**MARO DEVELOPMENTS LIMITED**

**ON BEHALF OF THE HILLARY FAMILY, IP AND SIGNIFICANT LANDOWNER**

**TR010064: Application by National Highways for the M60/M62/M66 Simister Island Interchange Project The Examining Authority's Written Questions and requests for further information**

**Compulsory Acquisition and Temporary Possession of Land and Rights**

WORKS PLANS
REGULATION 5(2)(J)
SHEET 5 OF 5

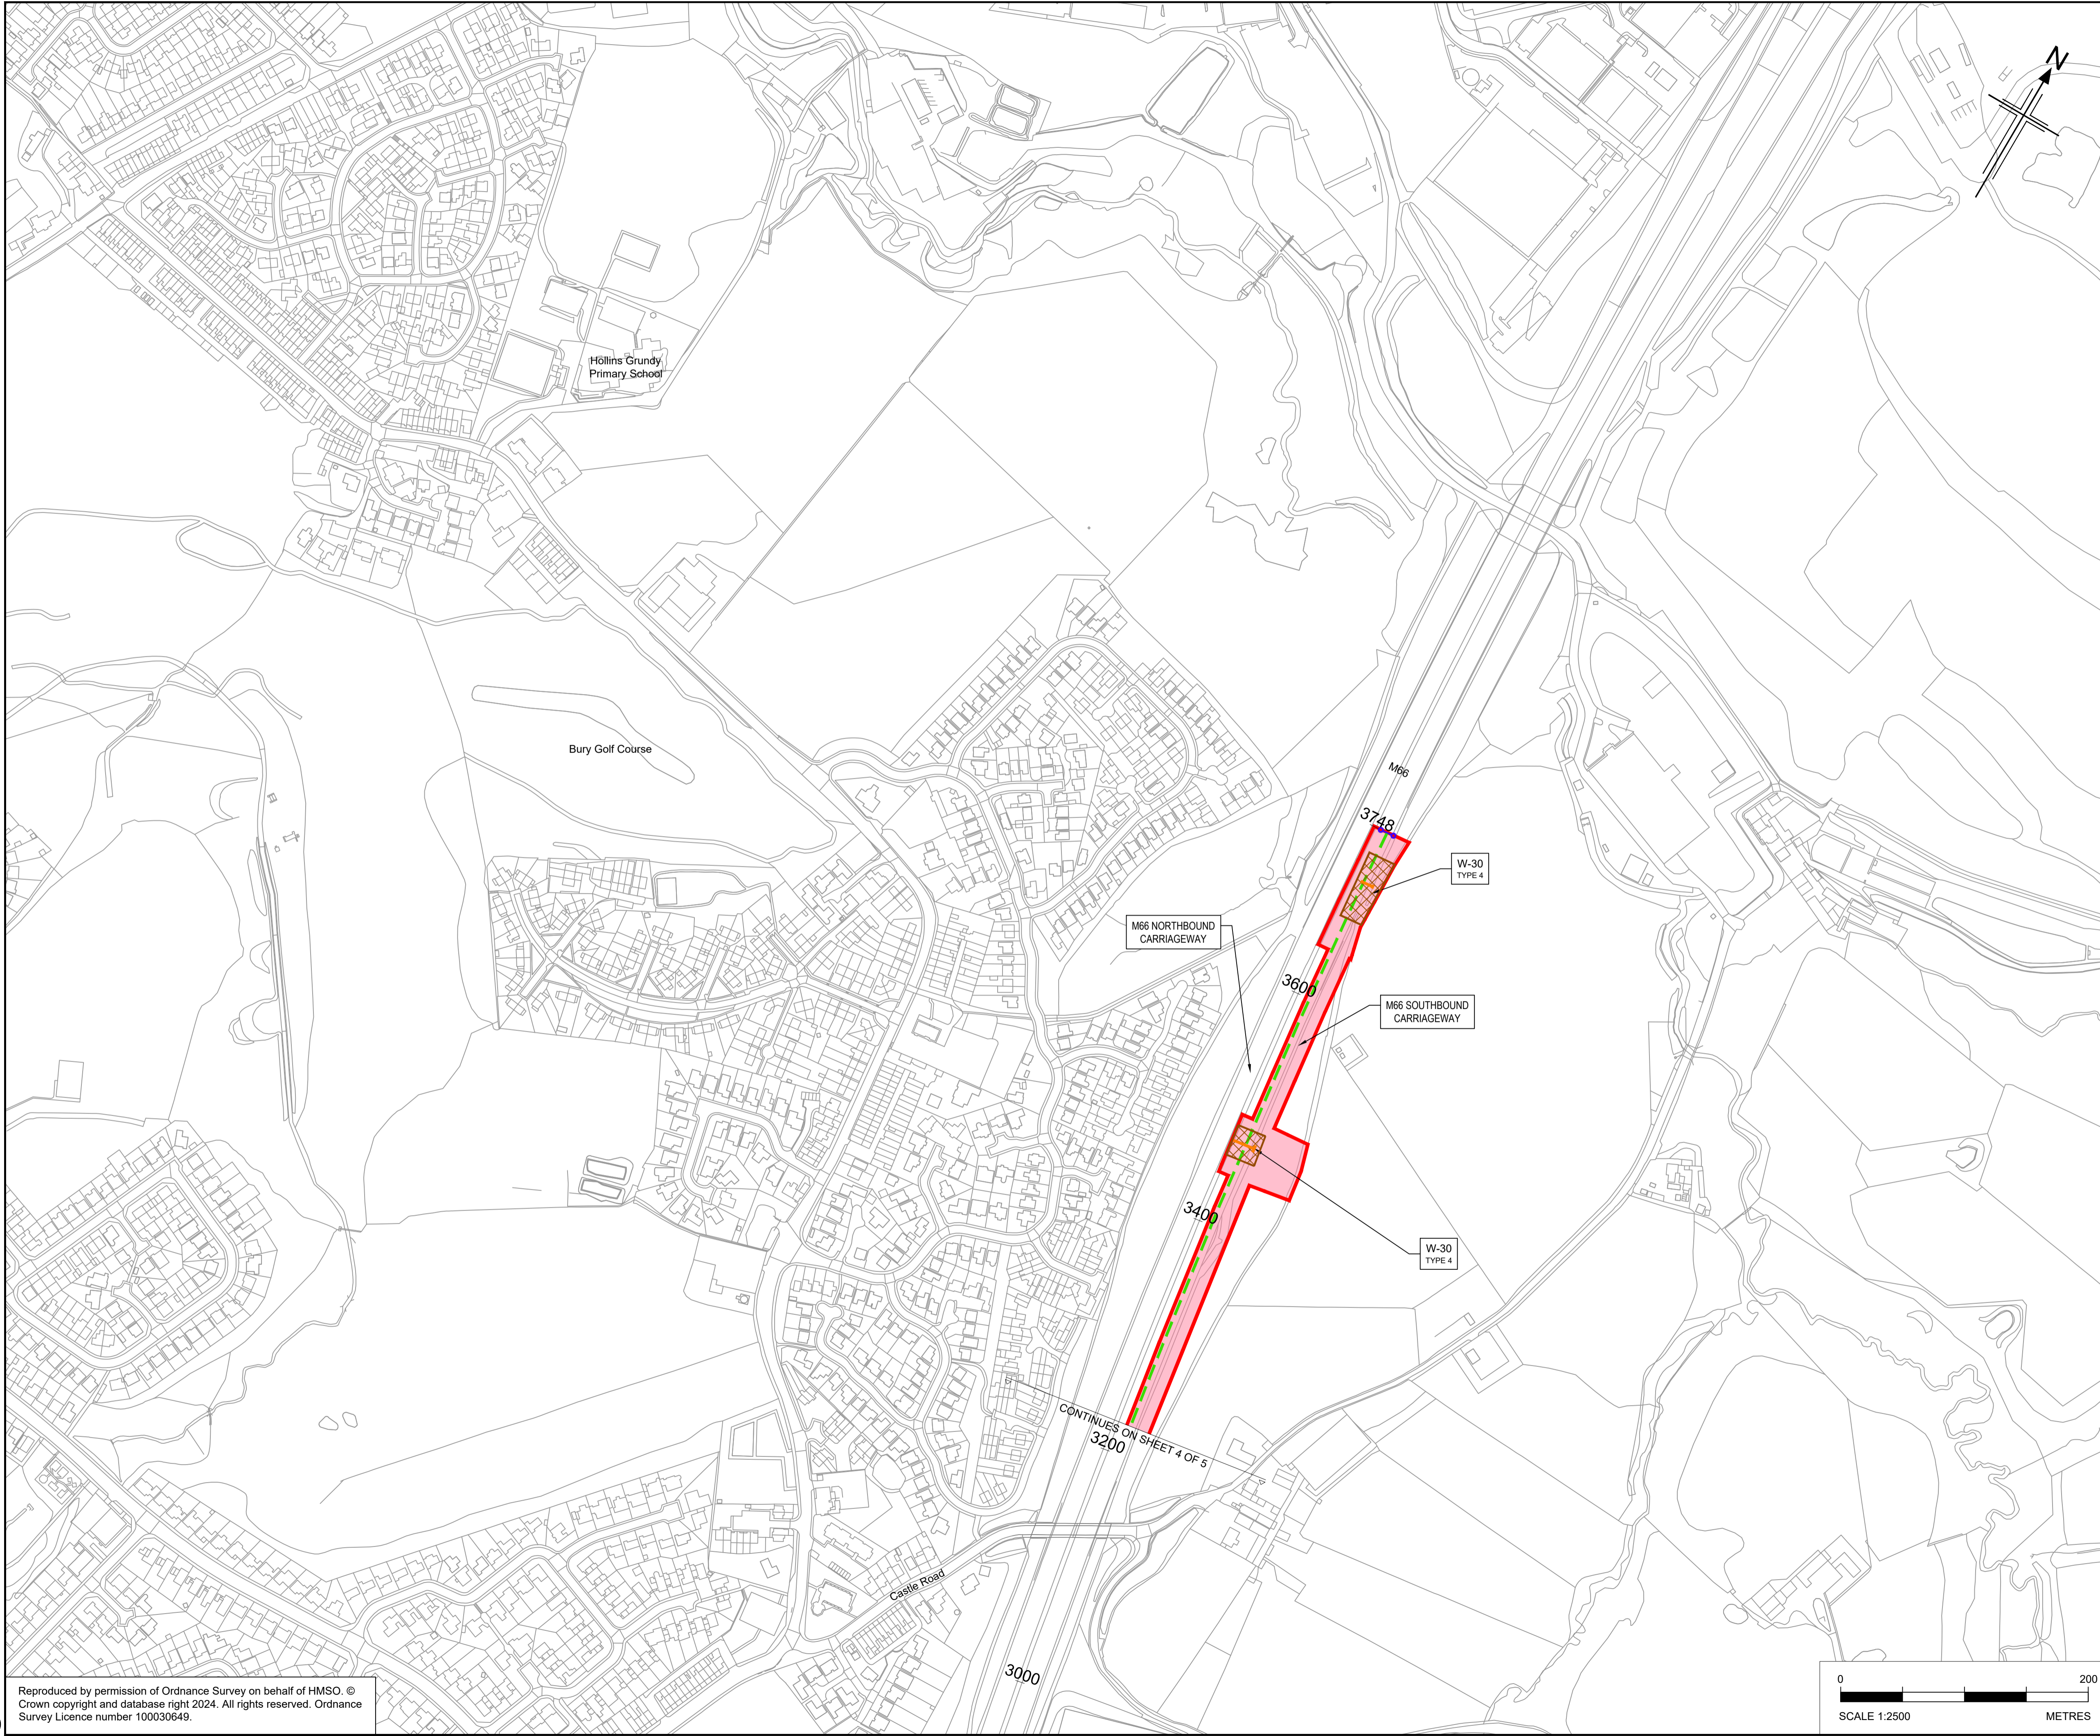
The whole of the two Environmental Mitigation Areas (EMA) outside and to the east and south-east of the northern loop, as identified in blue hatching on the Works Plans, falls within the ownership of the Hillary family.

All of the plans show the two EMA areas, referenced above, as Employment Development Areas.

The Hillary Family have no objection to the Compulsory Purchase of the 'Operational Land' comprising the area required for the permanent works construction of the Northern Loop itself, subject to appropriate compensation recognising its status and value as land allocated for Employment Development. Similarly, they have no objection to the occupation of the two EMAs on a temporary basis for as short a time as is practically necessary, including a period for its reinstatement, as was originally proposed, again subject to appropriate compensation for its temporary use. They do object to the two EMAs being acquired permanently (see REP4-031).
